**CITY OF PORTLAND, MAINE  
DEVELOPMENT REVIEW APPLICATION  
PLANNING DEPARTMENT PROCESSING FORM  
DRC Copy**

73 Roaring Brook  
Project Name/Description

TO: Inspections  
FROM: Jay Reynolds, Development Review Coordinator  
DATE: August 11, 2003  
RE: C. of O. for #73 Roaring Brook Road  
Lead CBL (397D003); Id# (2002-0132)

FOR: GILBERT P. GALLI
FOR A PROPOSED 2 STORY RESIDENCE AT: #73 ROARING BROOK ROAD, PORTLAND, MAINE
EXISTING CONDITIONS/ SITE PLAN

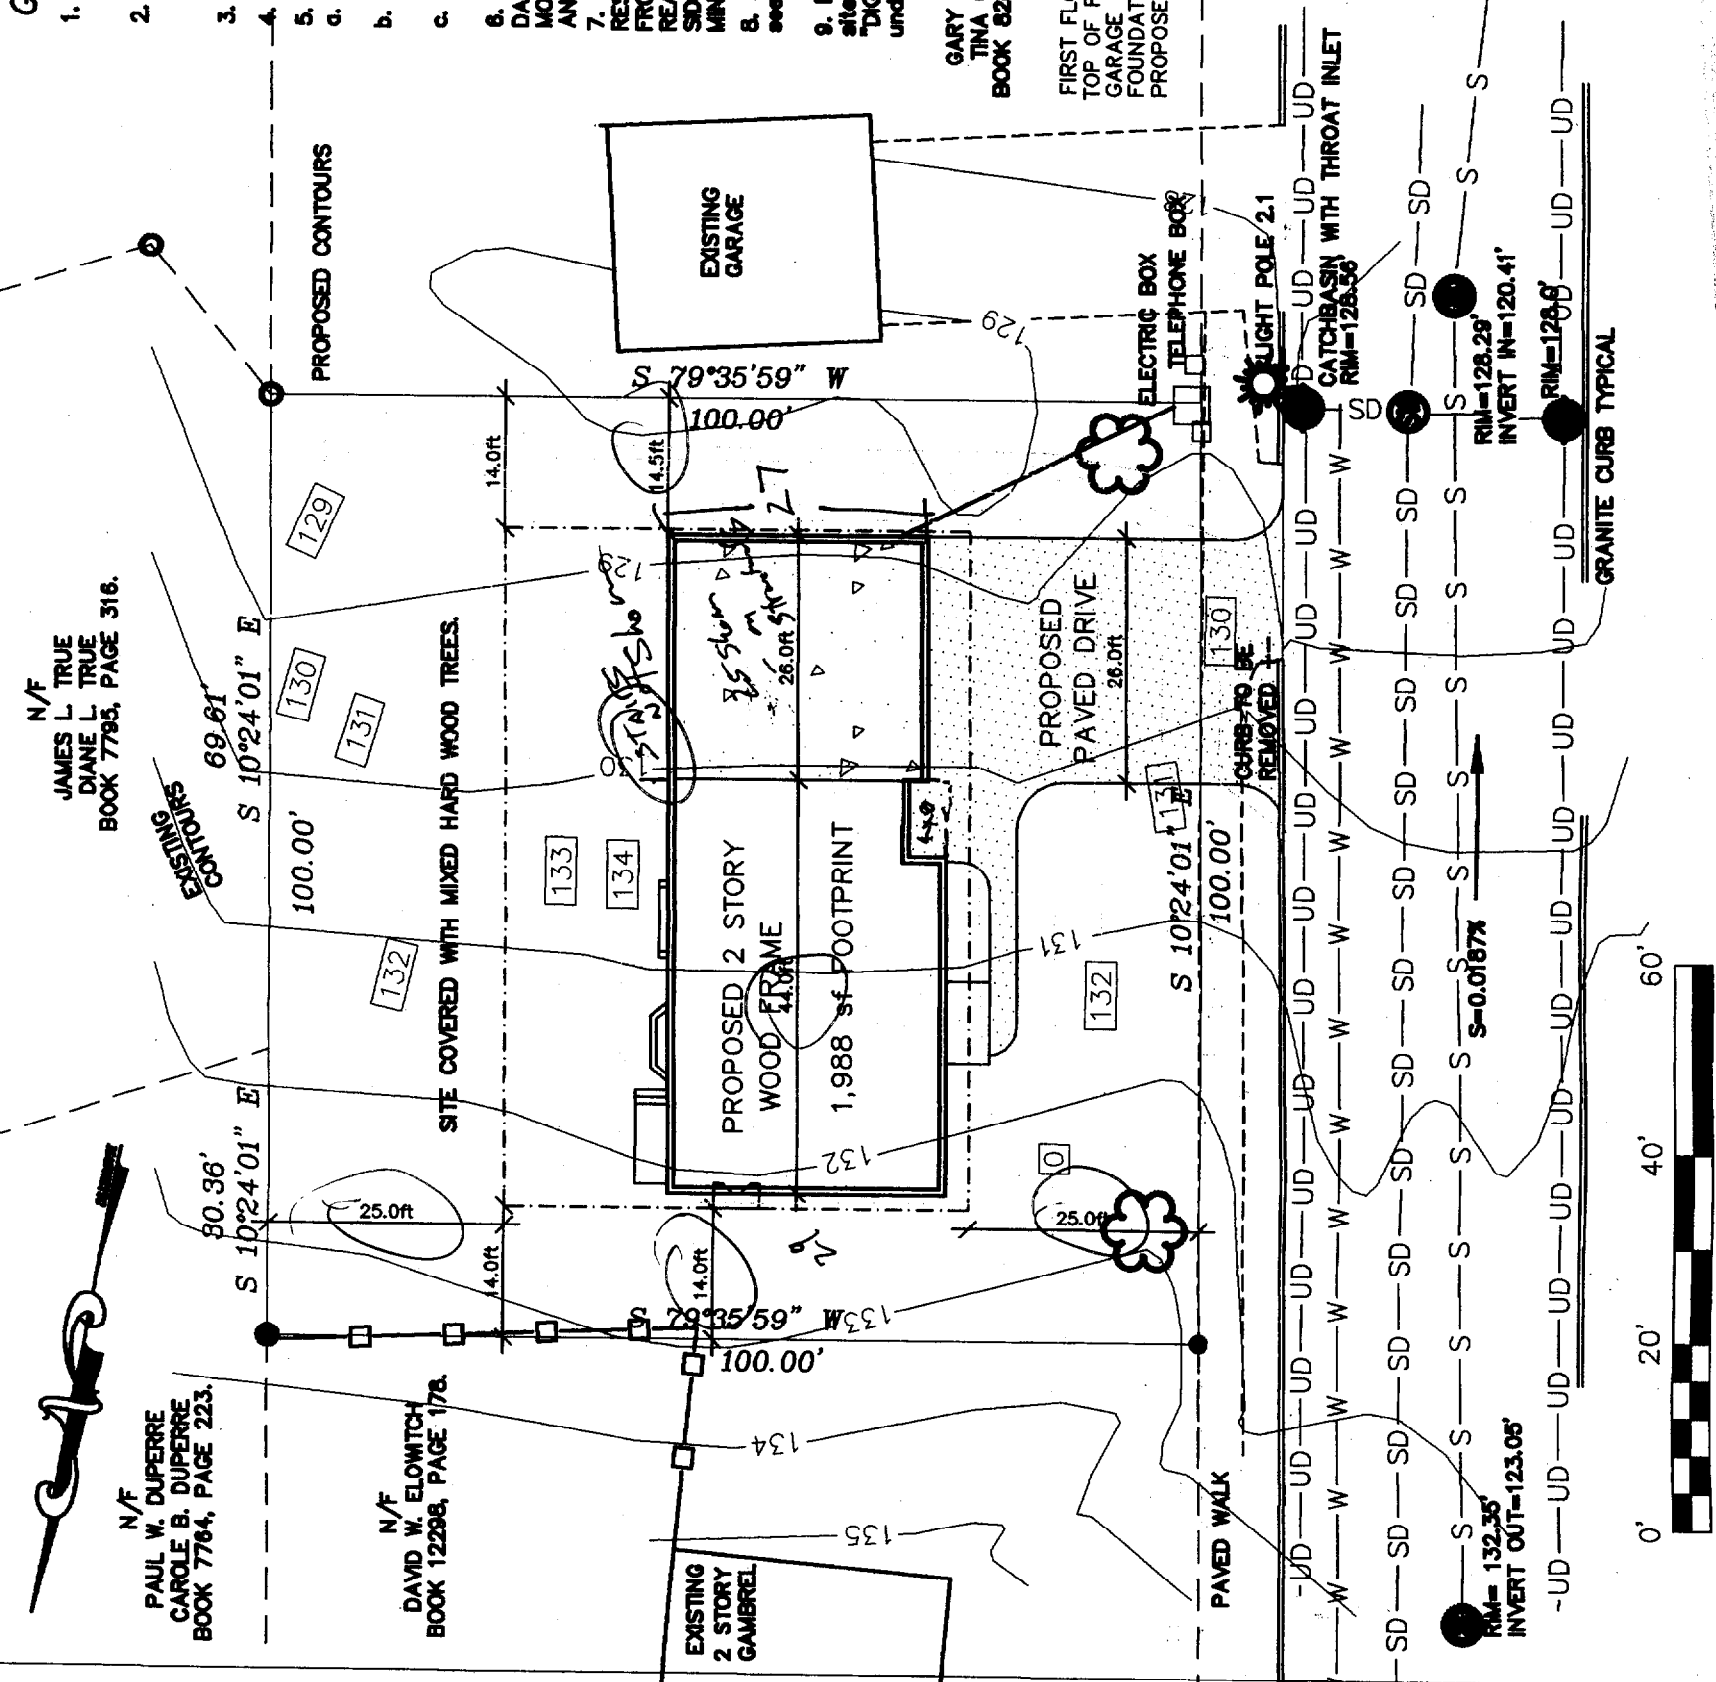
- 679
- lots visit for drainage
- 678
- 627
- 624
- Visited site w/ new plan
- Prop. contours don't meet
- Utilities
- Grading doesn't work very well
- with landscaping proposed
- Called 627
- Bob Greer
- 628
- Going to install 60
- And put utilities on
- Revised plan
